Your ref: 3/2018/0754

Date: 3rd January 2019

Planning Application 3/2018/0754: Creation of a new off-road, multi-use gravel track 2.5m wide between the villages of Downham and Chatburn. The one kilometre connection would accommodate walkers, cyclists, horse-riders and those with mobility issues including chair users. Field boundary alongside Chatburn Road Downham BB7 4DL

SECTION 1 : CHITBURN ROAD CROSSING GREEN LANE N.T.S. 116 METRES

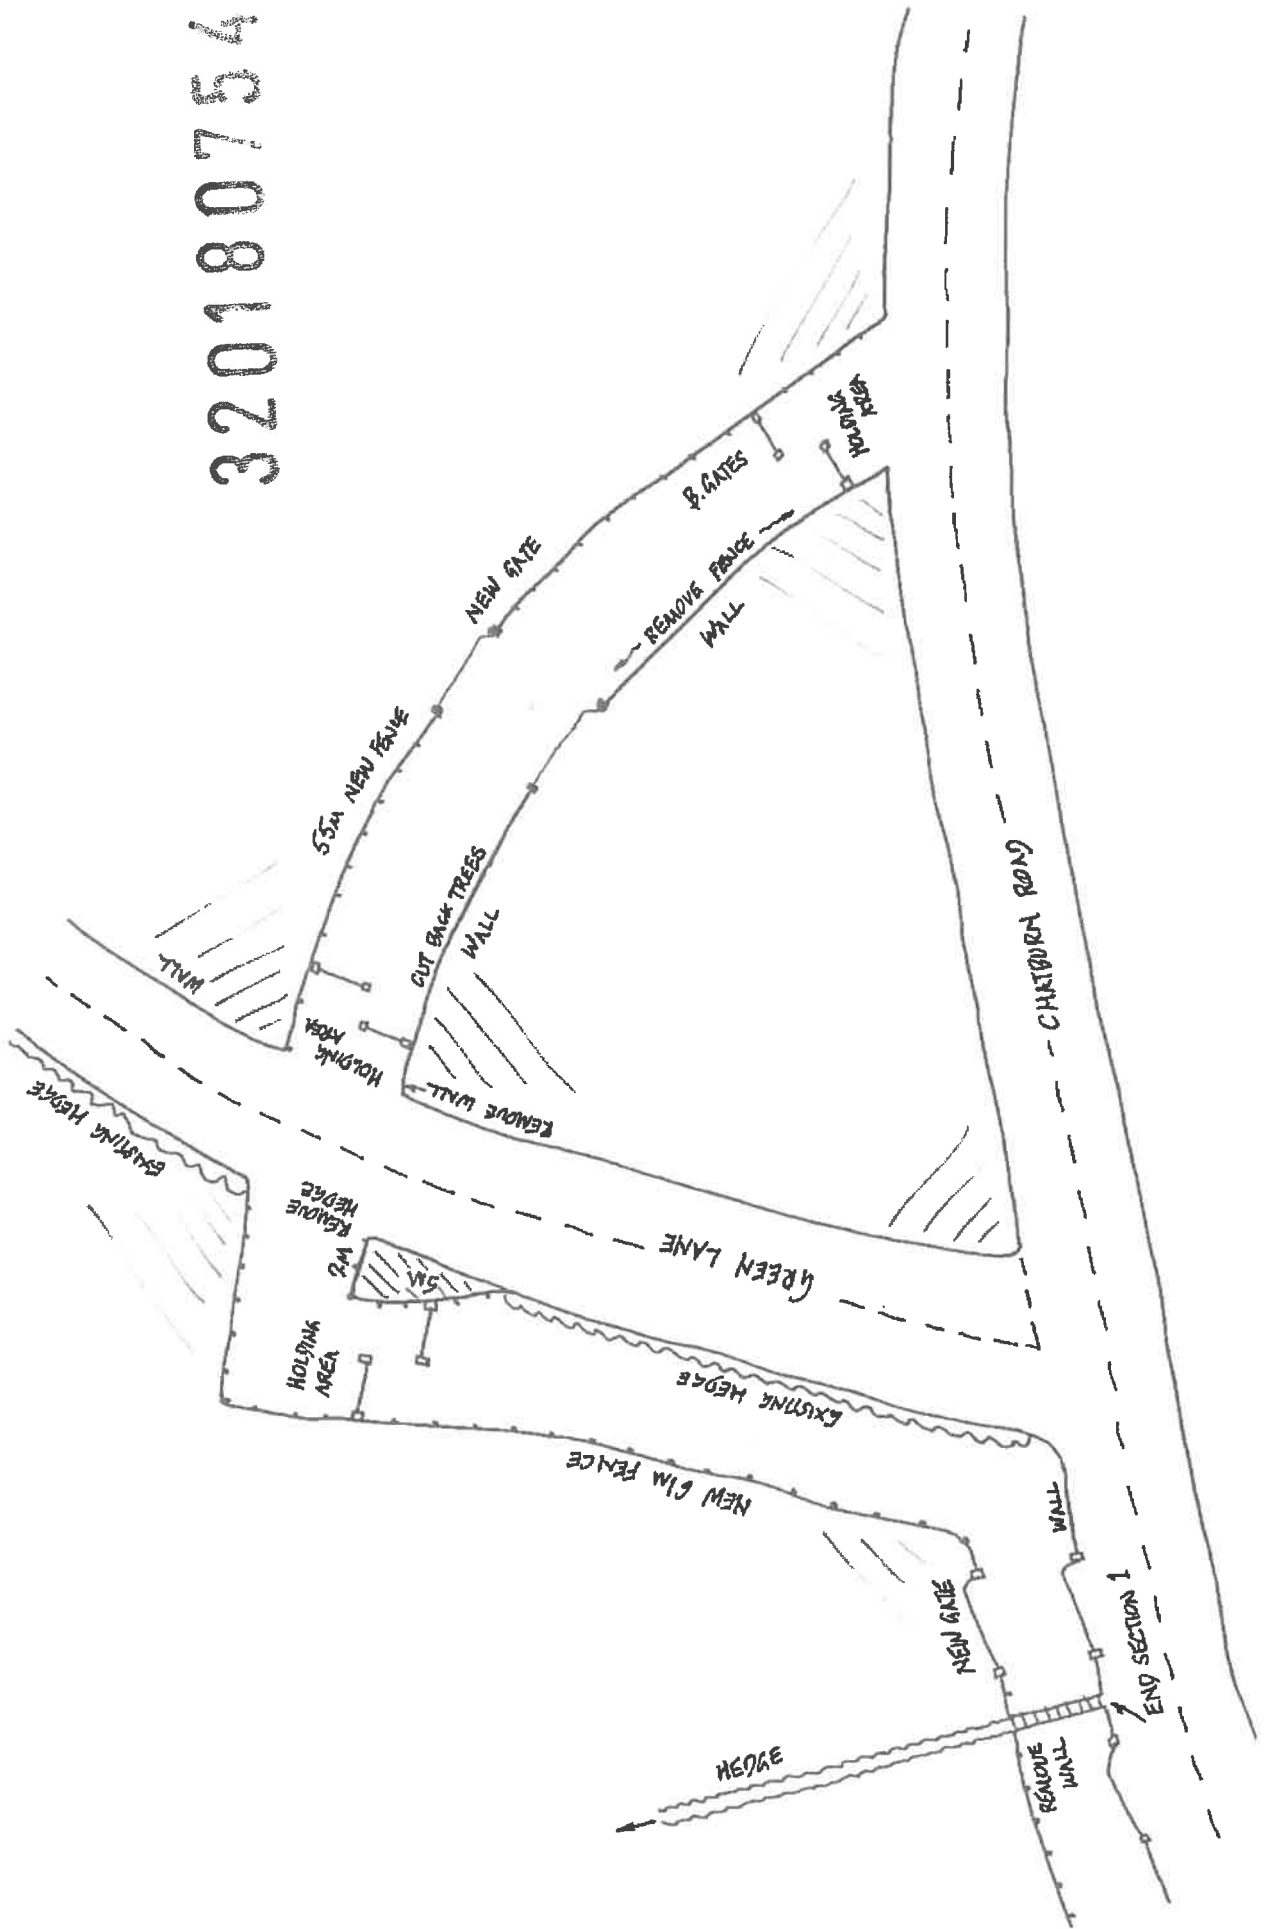
The line of this section of the Roman road is well-established and can be followed as an earthwork in Downham Park on the south side of Chatburn Road and running from the Green Lane/Chatburn Road junction slightly north of east into Town End Croft Wood and beyond. This line is described in both Ivan Margary's *'Roman Roads in Britain'* (1957, Vol. 2 pp.104-6) and Philip Graystone's *'Walking Roman Roads in the Fylde and Ribble Valley'* (1996, pp.80-2). The section to be crossed by the proposed path is recorded on the Lancashire Historic Environment Record (HER) as PRNs 15518 and 26145, it is also shown as an earthwork on modern OS vector mapping. The visible earthwork is likely to be the 'agger' or raised mound of the road, flanked by roadside drainage ditches. It is also possible that further parallel ditches, one to each side of the road line, existed to delineate a wider 'road zone' – examples of this have been found alongside other Roman roads in the county. The construction of this part of the path (Section 1) is likely to have a significant adverse impact on the remains of the Roman road and to require some archaeological mitigation and/or a change in construction technique.

- 2 Unless all remains can be shown to have already been destroyed, the section of path that crosses the Roman road should be redesigned to minimise ground disturbance and thus damage to the remains.
